Mr. Chris Ritchie
Manager- Industrial Assessments
Department of Planning & Environment
GPO Box 39
SYDNEY NSW 2001

24 July 2015

Eastern Creek Energy from Waste Facility – SSD 6236

Title
GENERAL ARRANGEMENT PLAN

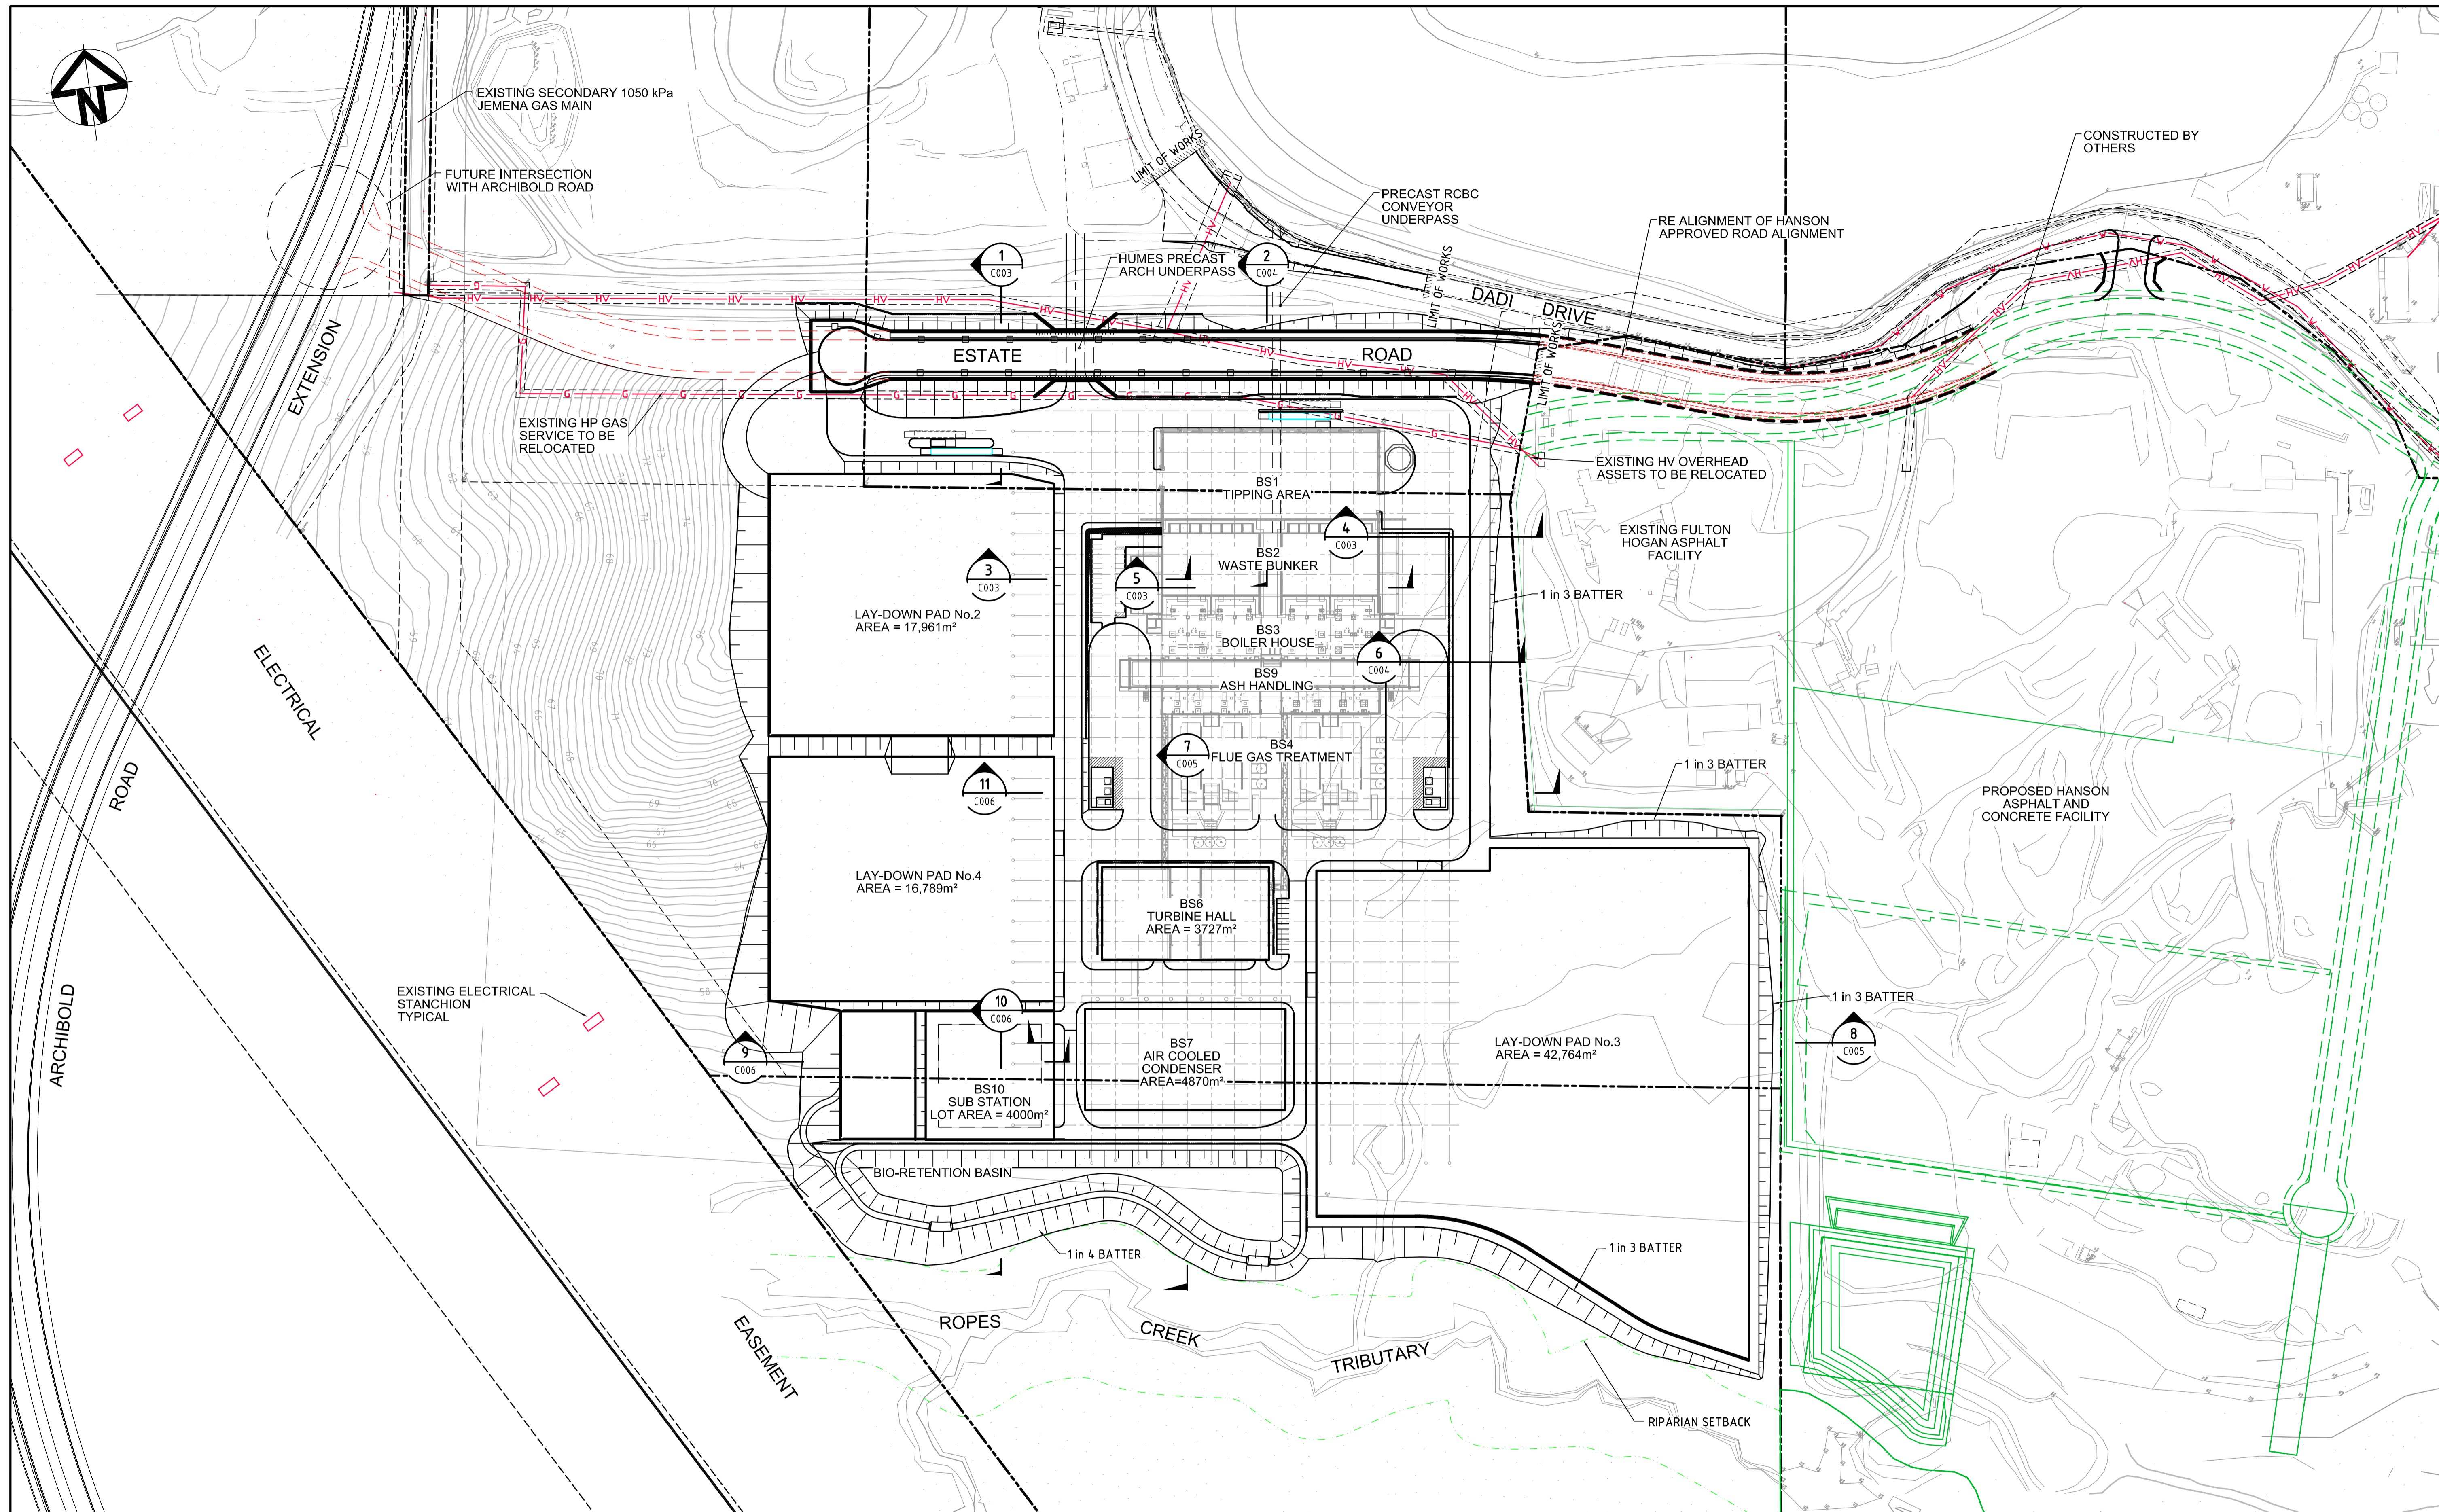
The EIS proposes to realign the approved (under MP 06_0225) Precinct Plan Road alignment across the Hanson land. No consultation by the applicant regarding this was made prior to submission. The proposed realignment intends to subject land to development approval under SSD 6236 which is not included in the application, nor has land owner's consent been provided, nor has the land been formally identified in the EIS. The proposed realignment would require a Geotechnical assessment to be carried out by the applicant to determine the suitability as a location for the Precinct Road.

The EIS contains no information on the purpose and use of the laydown pads. The applicant proposes to construct laydown pad No.3 immediately west of the Hanson land. No information has been provided on what materials will be place and stored on these pads and whether the materials will be hazardous to people or the environment.

Project	ENERGY FROM WASTE ELECTRICITY GENERATION PLANT, EASTERN CREEK
Title	BULK EARTHWORKS CUT AND FILL PLAN

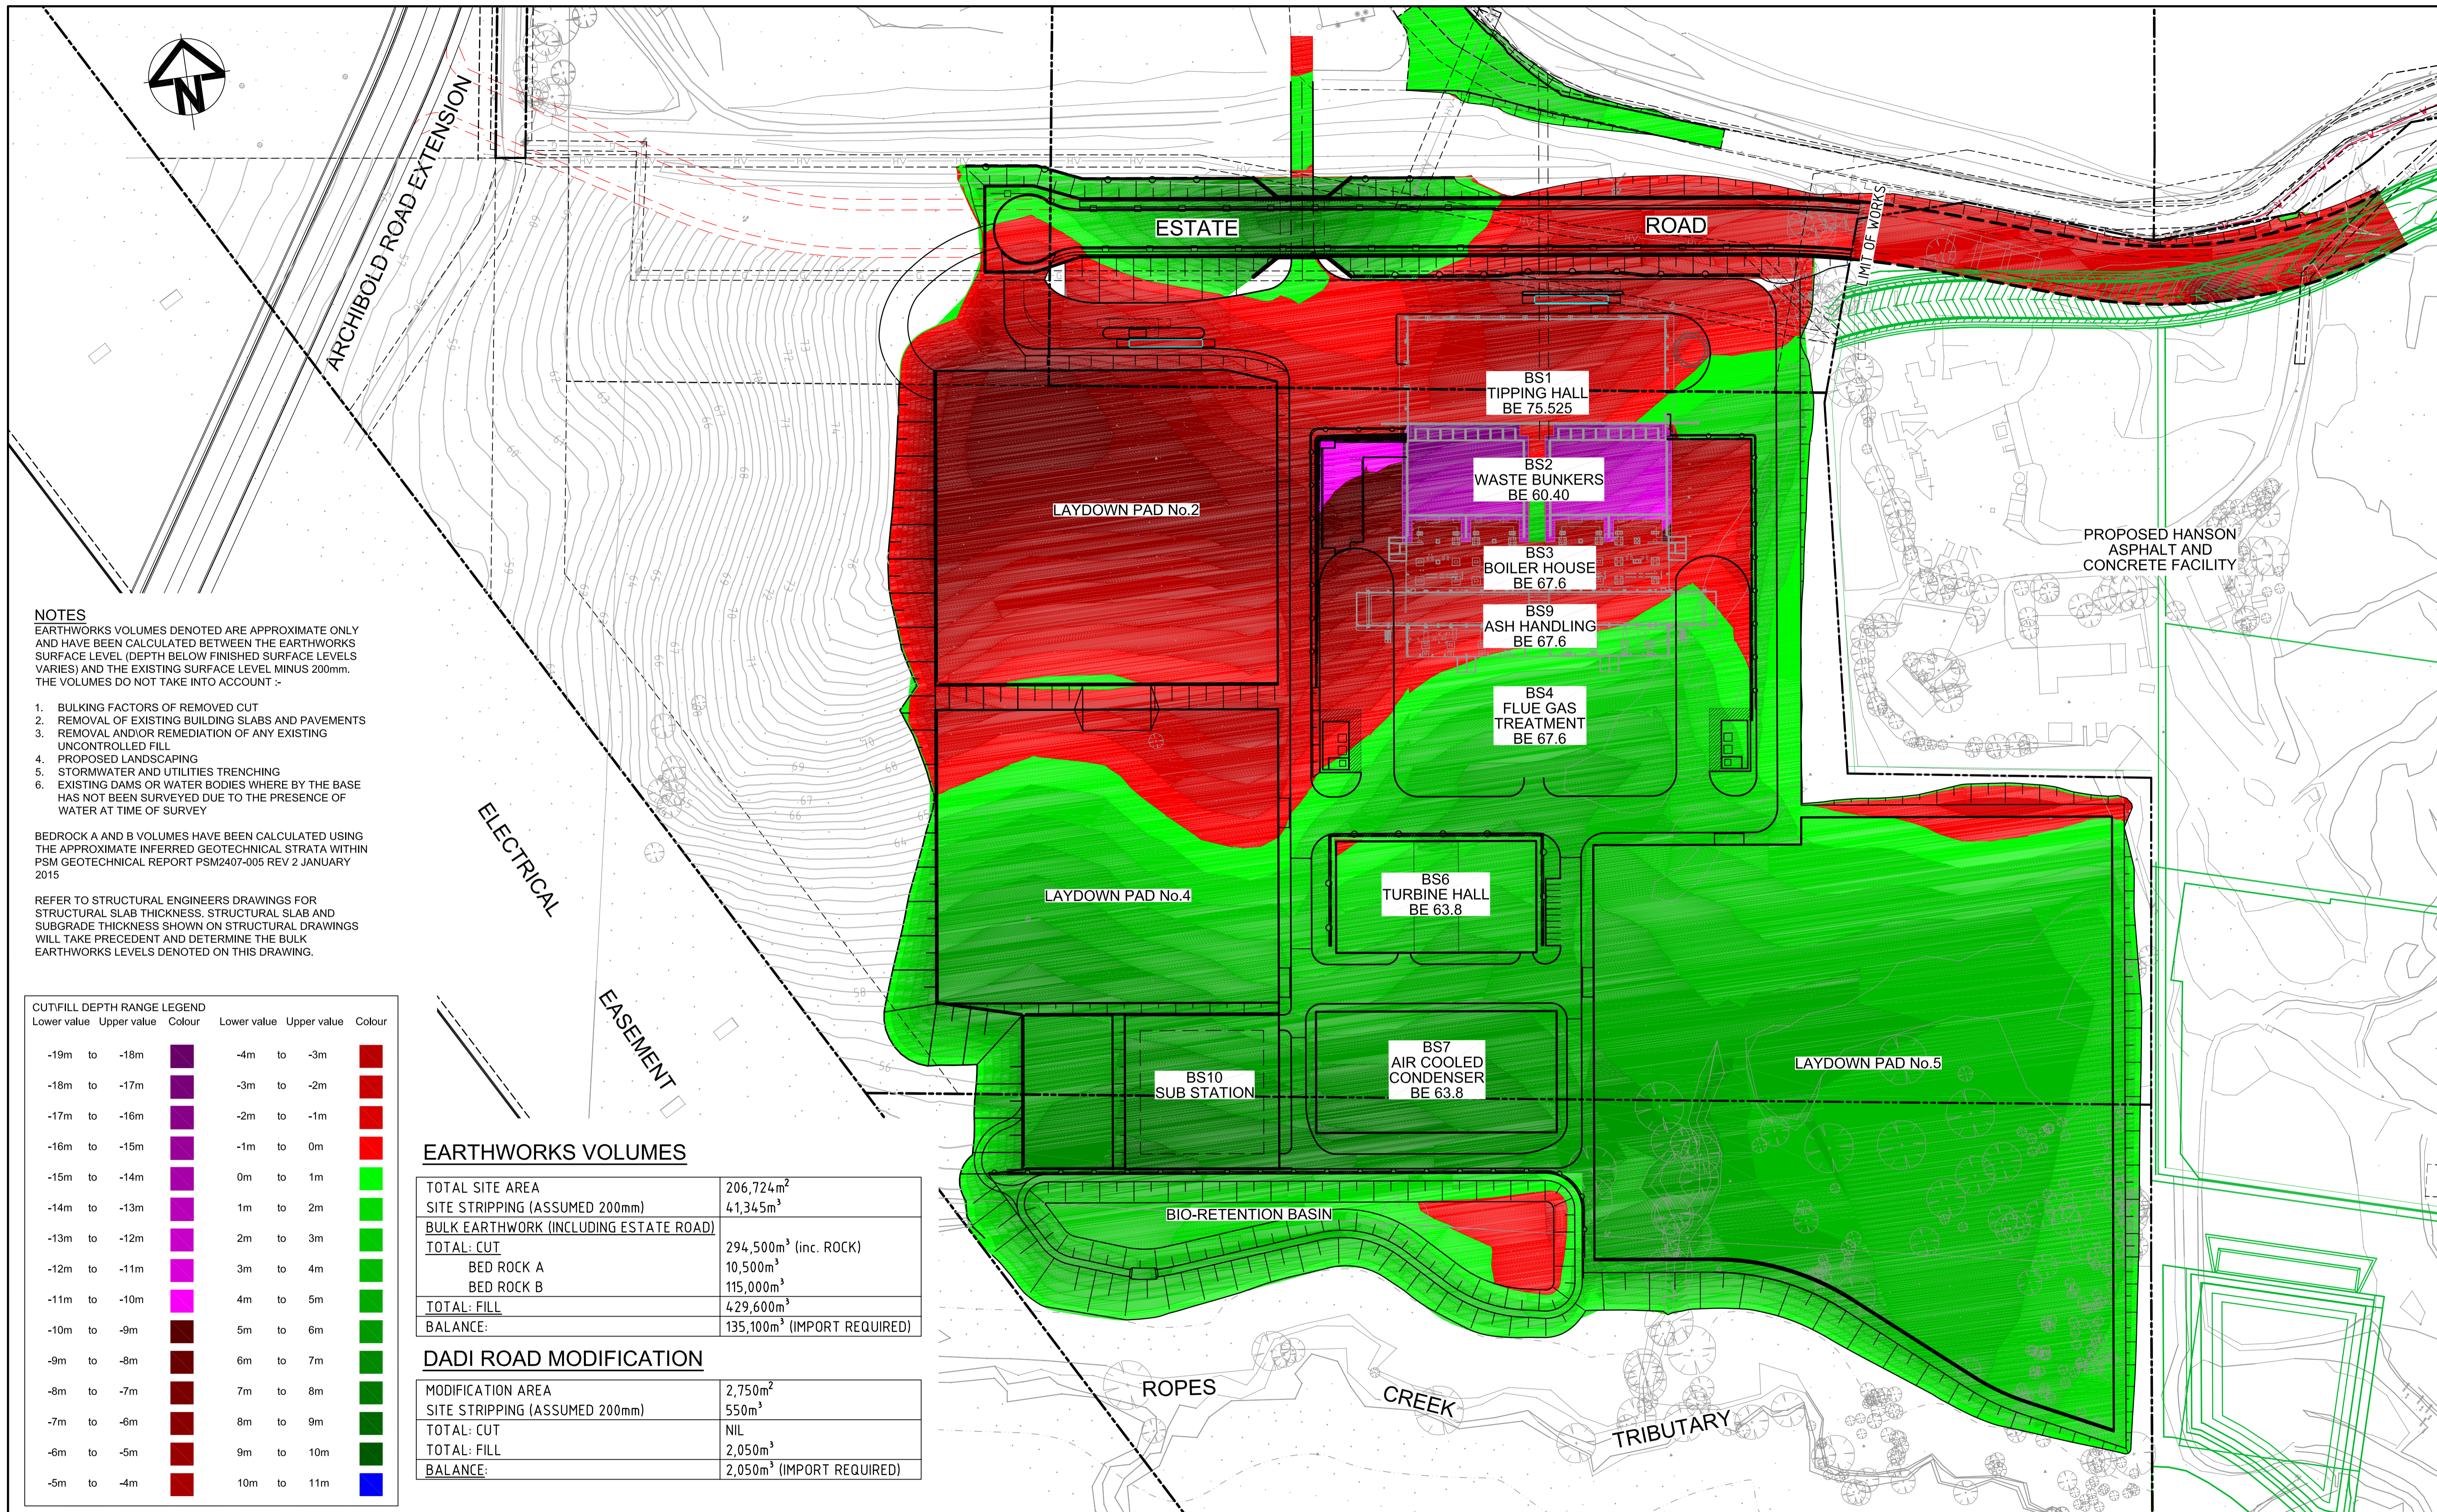
The EIS contains no information on the purpose and use of the laydown pads or whether the surface of these pads will be sealed or unsealed. The laydown pads constitute an area of 77,514m² (7.7 hectares) and are proposed to be constructed on unsealed fill. Unsealed surfaces will generate dust and particulate emissions, especially when driven over by heavy vehicles.
